Freedom Forever
Planset Revision Letter

6/5/2023
REV #1

WILLIE MATTHEWS
400 EAST I STREET, ERWIN, NC 28339

REV1 - 6-5-23 - Layout updated.

**SITE PLAN**  
 SCALE: 1/16" = 1'-0"

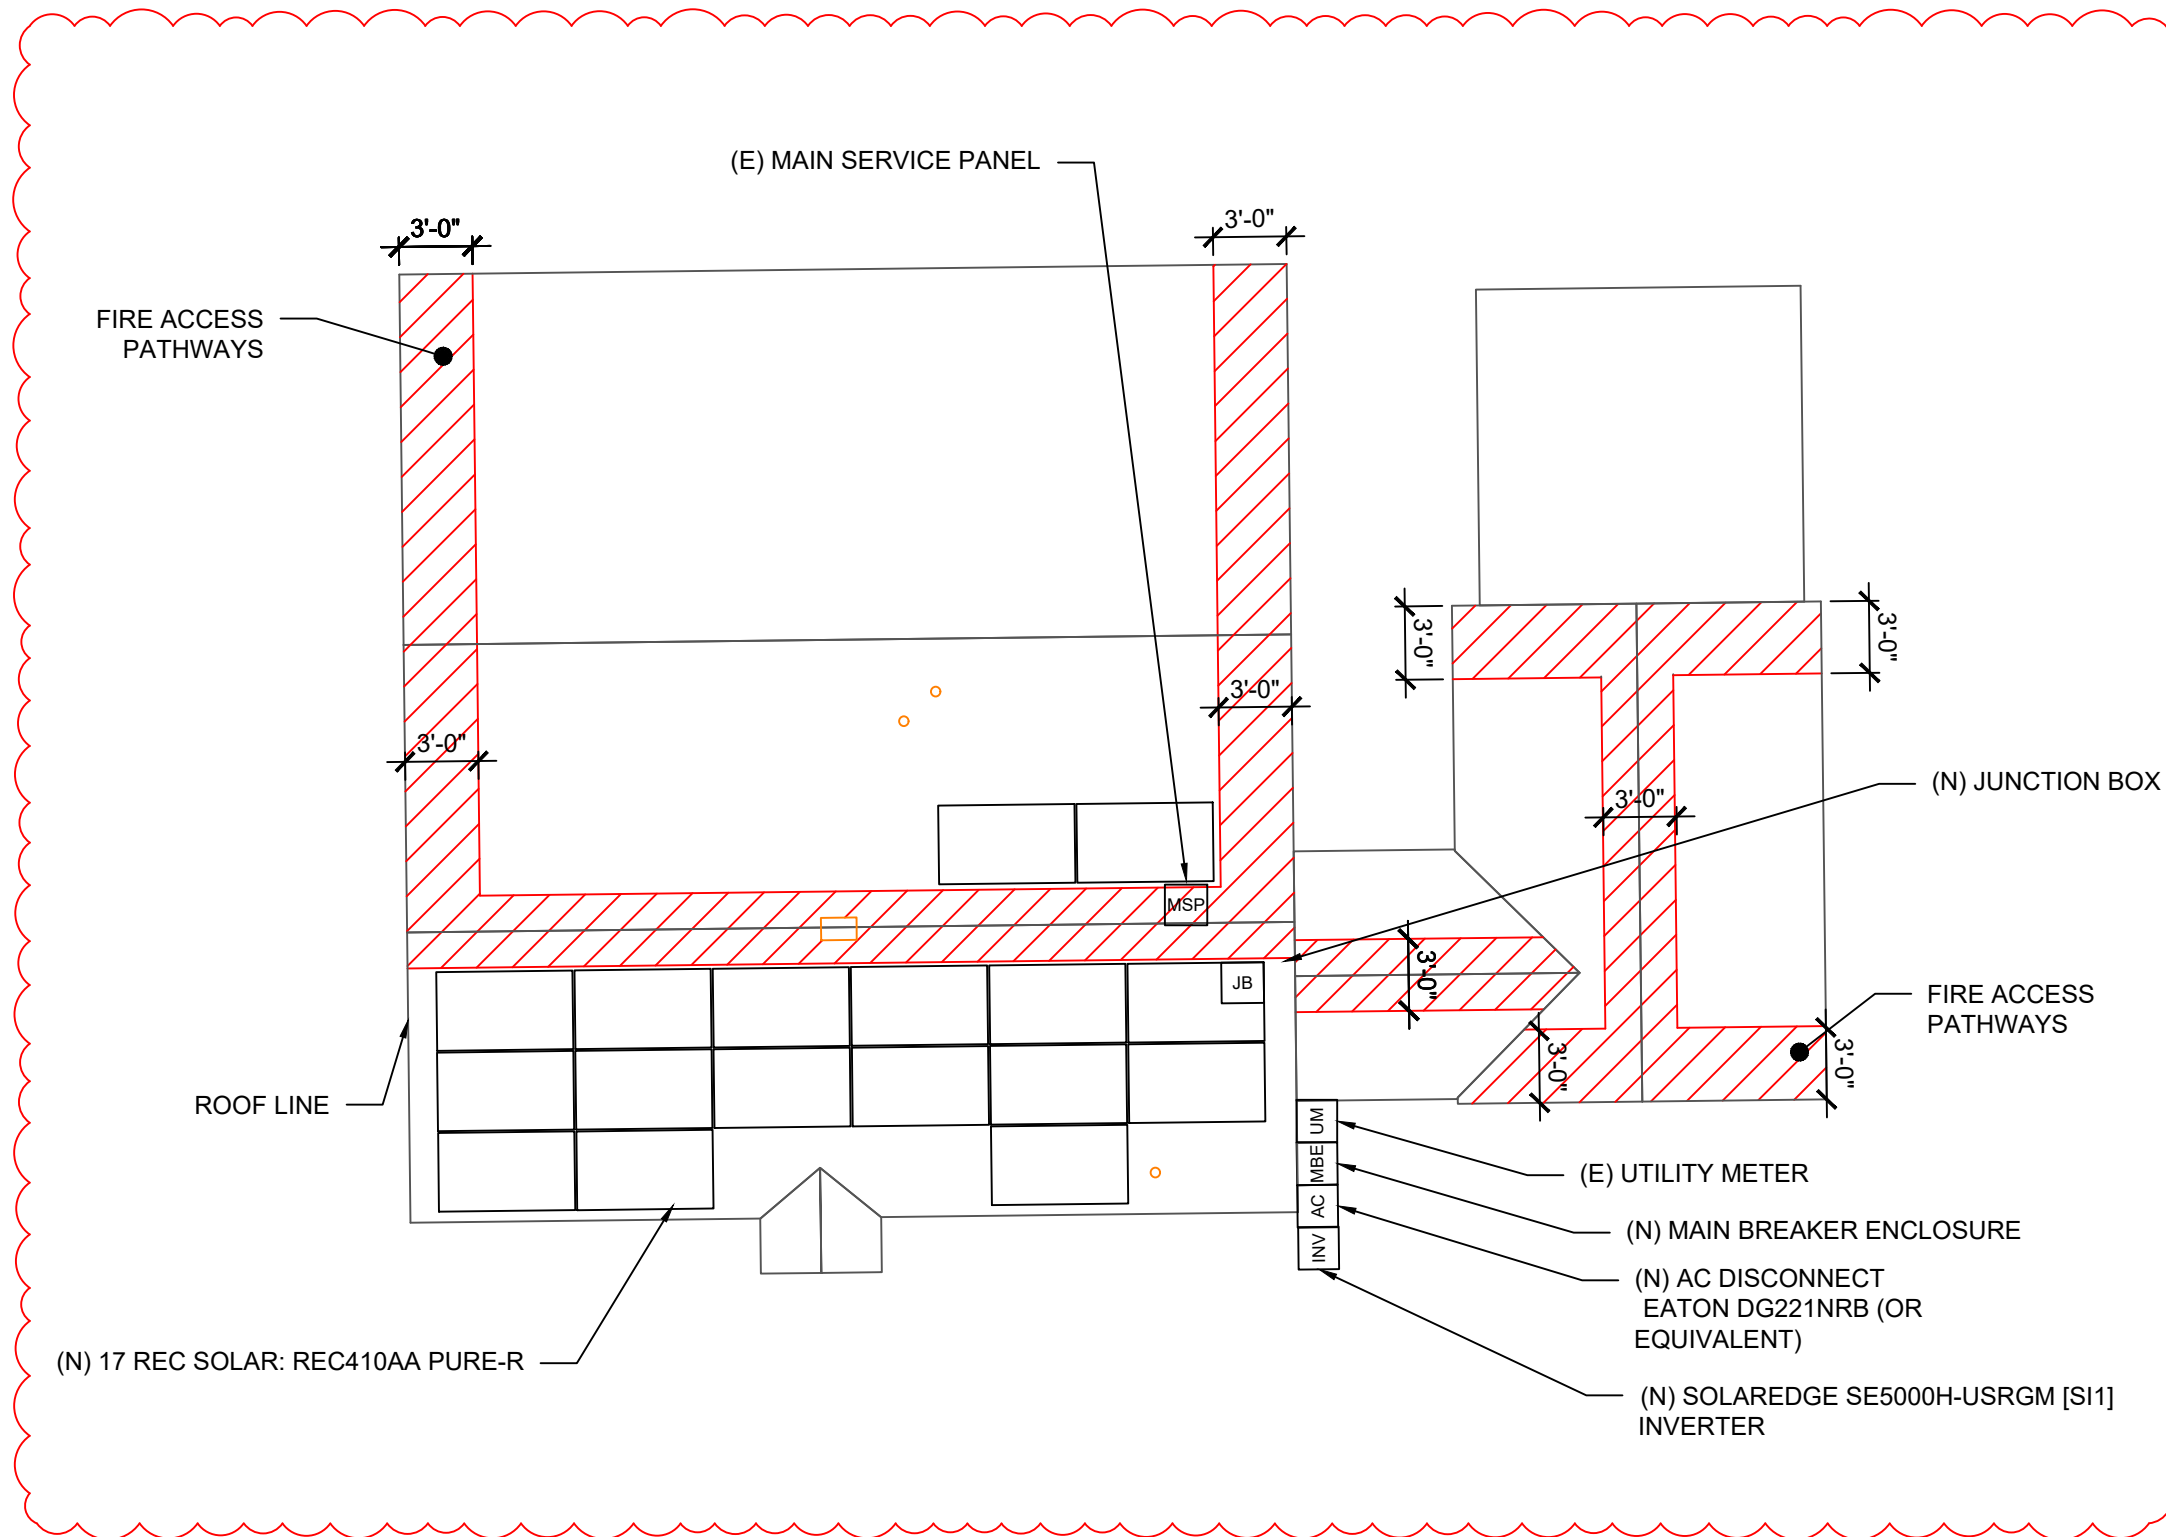
All corresponding changes are notated on the plans by revision clouds.
